Appeal Decision

Appeal Ref: APP/T2350/A/12/2184630

51-53 Knowsley Road, Wilpshire, Blackburn, BB1 9PN

Summary of Decision: The appeal is dismissed.

Drawing Title
Proposed Site Plan

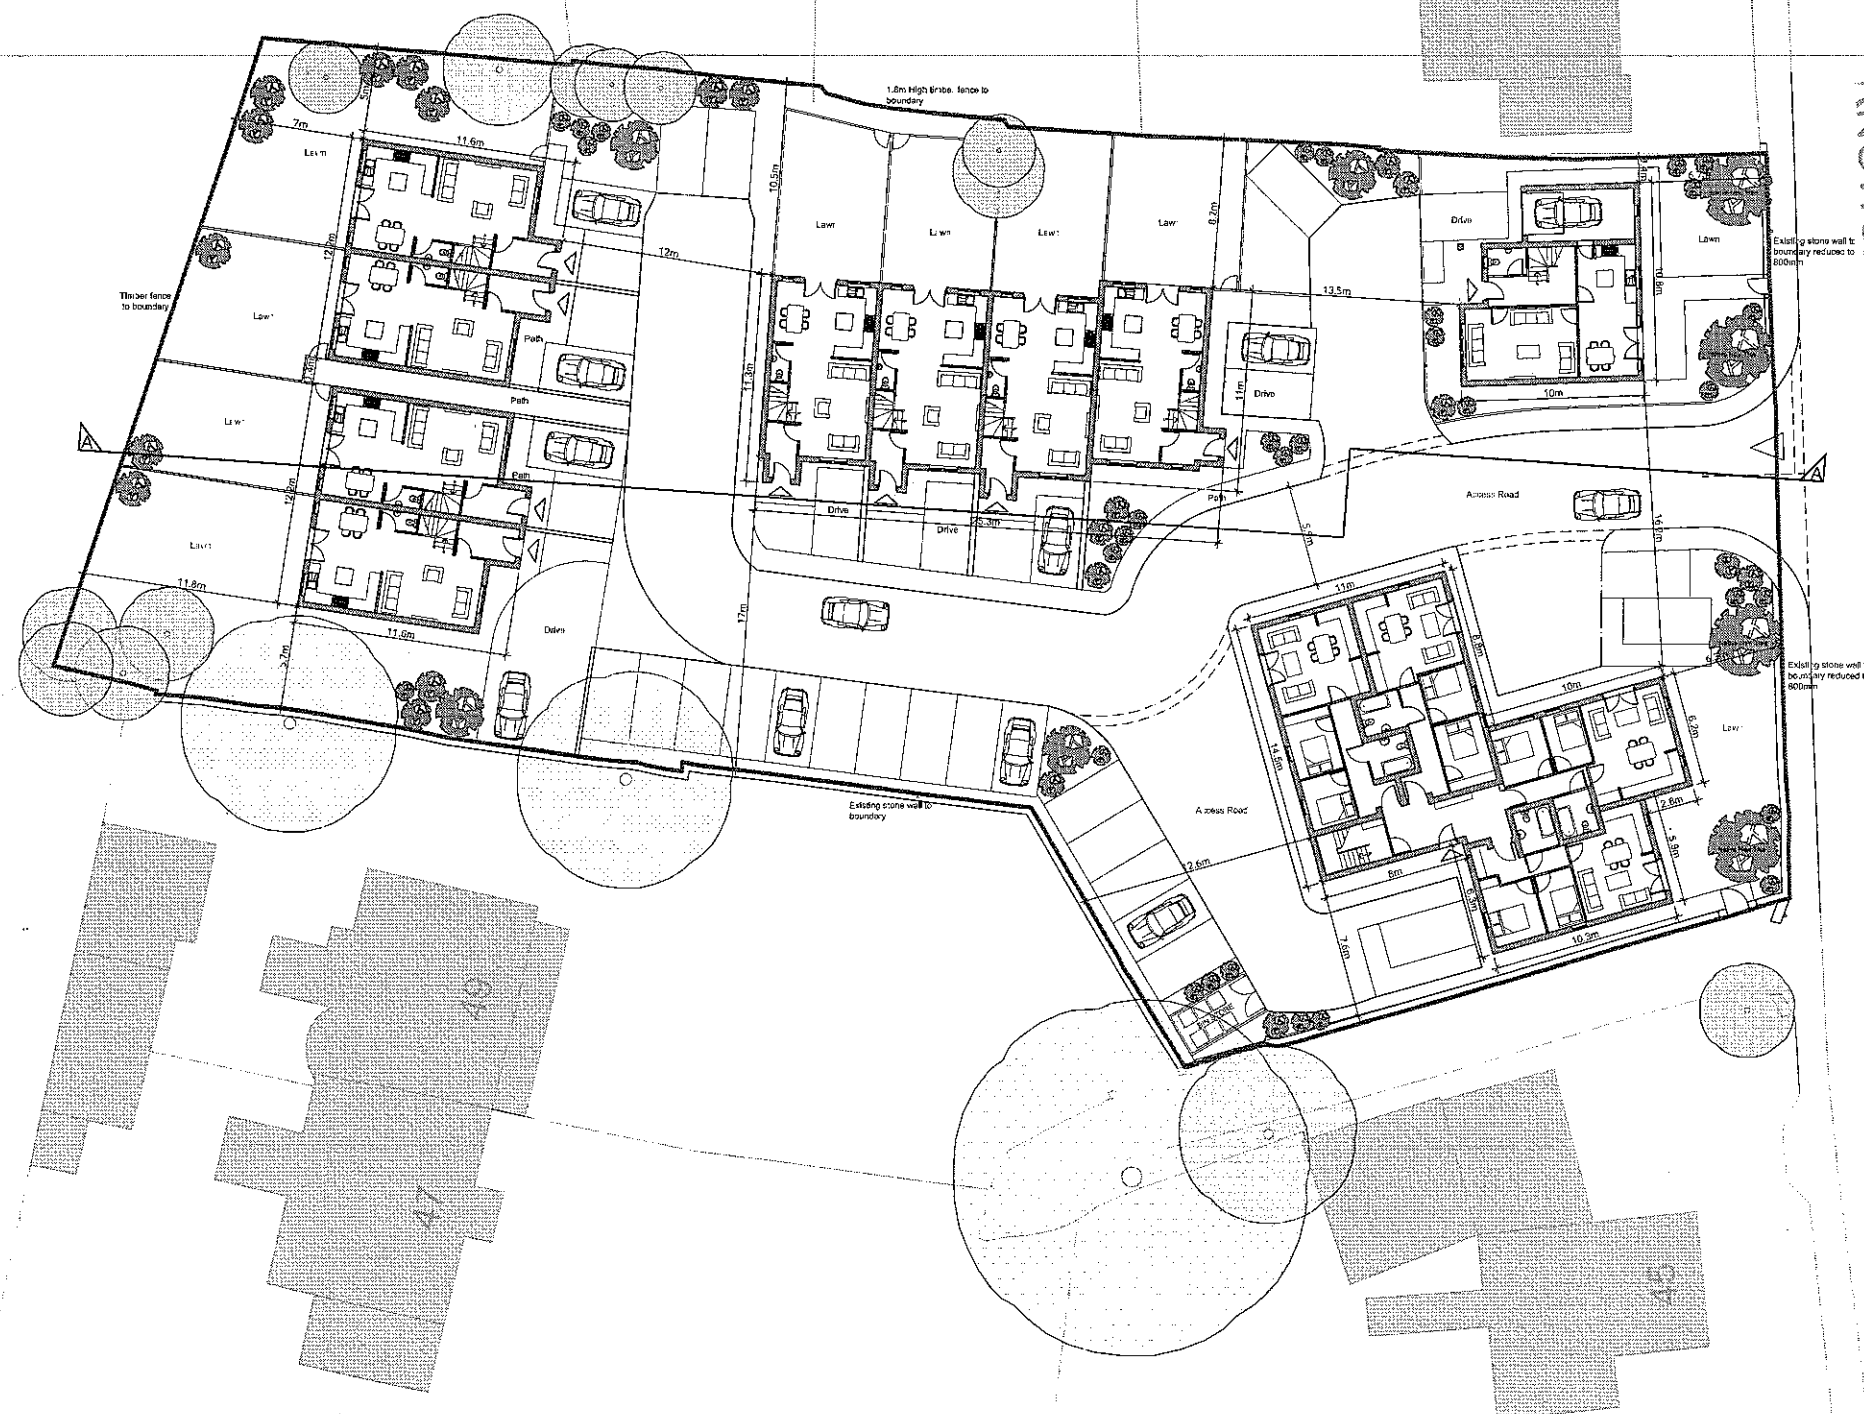
9. Turning to the character of the site layout as a whole, it appears to me to be unduly dominated by the hard surfacing of the access road and of the adjacent expanse of car parking bays. There is little opportunity within, or on the periphery of, the site for sufficient landscaping to soften the impact of the built form. In my view, this unsatisfactory characteristic arises from the excessive amount of built development which the appellants seek to accommodate on site.

11. There are dwellings to the north, south and east of the appeal site. Turning first to the north, the proposed terrace of Units 2-5 would back on to the rear gardens of nos.55, 57 & 59 Knowsley Road, which are at a significantly higher level than the appeal site. Unit no.2 would be only 8m from the boundary with no.55 and would be in a position where its occupants could overlook, and be overlooked by, the occupants of no.55. The presence or positioning of any fenestration on the north elevation of the new dwellings cannot yet be determined but there appears to be an intention to have rooms in the roof space. Therefore, even though the new dwelling could be up to 2m lower than

the neighbouring garden, this relationship appears unacceptable. The introduction of high fencing to the rear boundary, sufficient to provide a screen, would be likely to appear overbearing to the occupants of Unit 2. I find the impact of Units 4 & 5 to be less harmful as they are designed to be at a lower level and would affect only the very rear part of the neighbouring gardens of nos.57 & 59.

15. In conclusion, I find that the size and proximity to the northern boundary of the terrace which contains Units 2-5 to unduly diminish the living conditions of the occupants of no.55 Knowsley Road and of the future occupants of Unit 2, contrary to the aims of the development plan.

Drawing Title: Proposed Elevations and Section

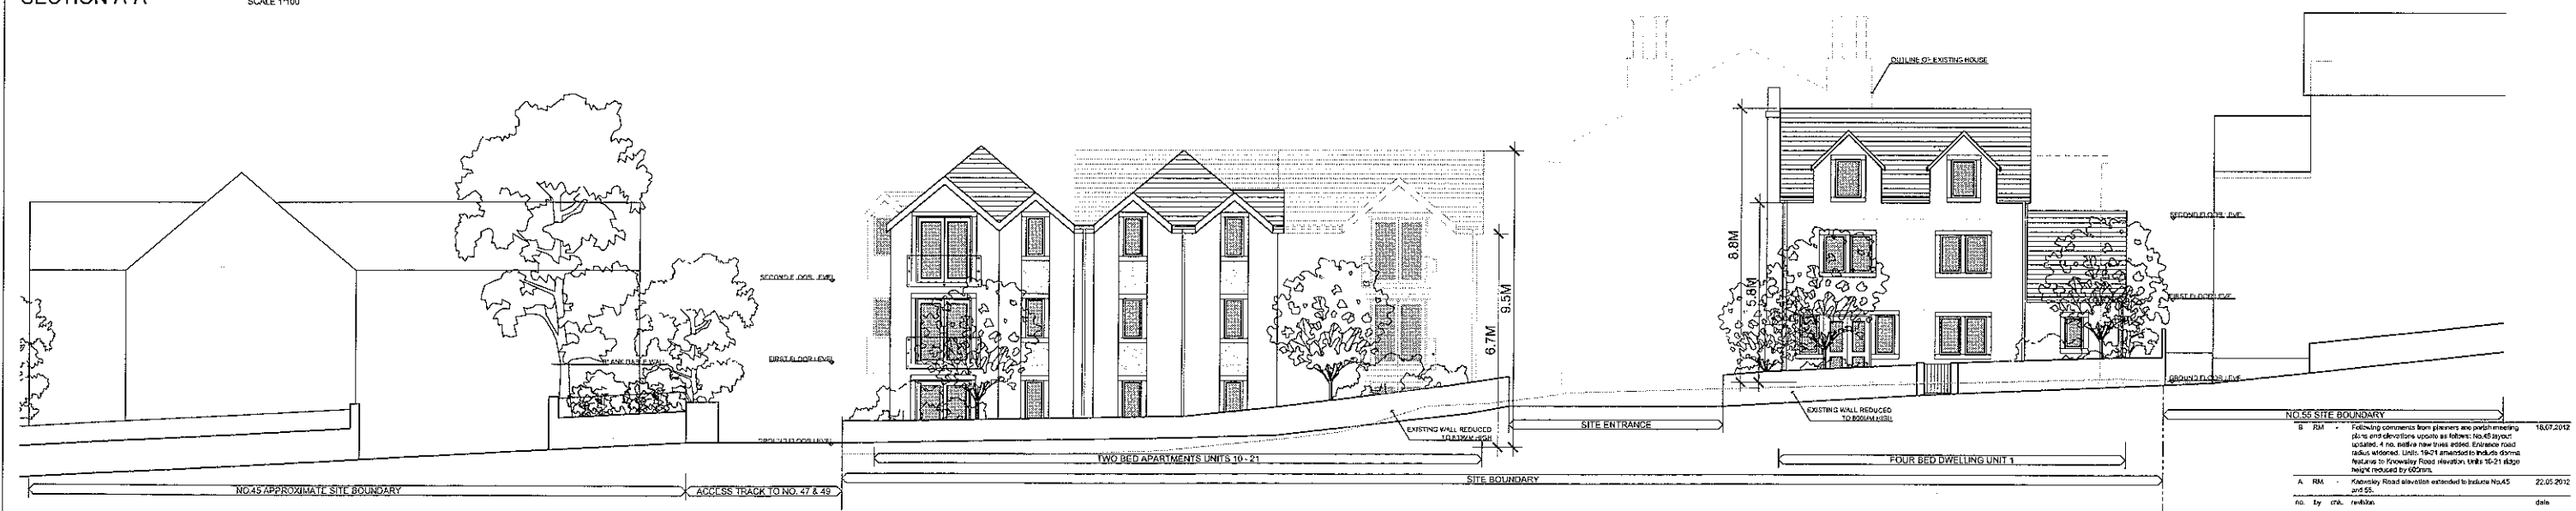
8. The proposed development would clearly be at a much higher density than is presently found on site, although that is not in itself objectionable, so long as it remains in keeping with the character of the area. Nor do I find the proposal to include apartments as inherently objectionable; they would add to the variety of the housing mix in the locality. The proposed detached house and apartment block fronting Knowsley Road appear to me to be of an acceptable scale and massing when compared to the existing house, no.53 and the dwellings on either side, nos.45 and 55. However, given its size, the proposed apartment block appears to me to be unduly close to the road, such that its imposing visual presence could not be suitably mitigated by landscaping. I find this harmful to the character and appearance of the street scene.
